# HERTFORDSHIRE ECOLOGY

Date: 20/10/2022

**Reference:** 6/2022/1853/MAJ  
**Address:** Eisai Europe Limited, European Knowledge Centre, Mosquito Way, Hatfield, AL10 9SN  
**Application:** Construction of a 4,012sqm extension to the existing warehouse space (Use Class E) with associated plant and works including the relocation of a bicycle shelter, re-routed internal access road and landscaping

There are currently 518 car parking spaces (originally the consent for the application granted 618 parking spaces, leaving 100 spaces for future requirements) for the existing 650 staff and visitors. Due to hybrid working, the current number of staff on site on any given day is estimated at 400.

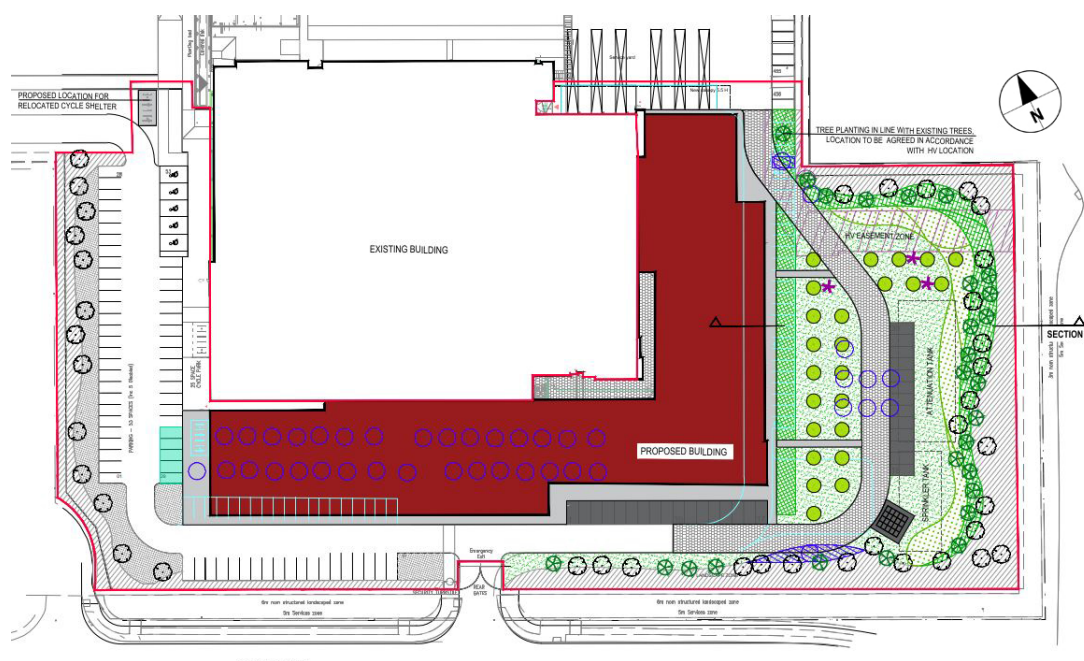
A Phase 1 Habitat Survey was undertaken on the 20th of May 2022 and describes a site dominated by buildings, hard standing, areas of amenity grassland introduced shrubs and ruderal vegetation and suggest that the proposed development site supported only modest ecological importance. There will be a loss on site of habitat features and trees to accommodate the proposals, but I do not consider that the habitats affected are of sufficient value to represent a fundamental constraint. Forty young trees are proposed for removed and should be compensated for on a 1: 1 basis preferably with native

species. Although, the landscape plan drawing 60681916-ACM-XX-XX-DR-L-00600, shows only 26 new trees I note that it states the drawing was produced prior to a tree survey being carried out and would need updating accordingly. like-for-like basis with plantings being within the Site. The LPA should expect updated plan to demonstrate full compensation for being lost for the trees being lost.
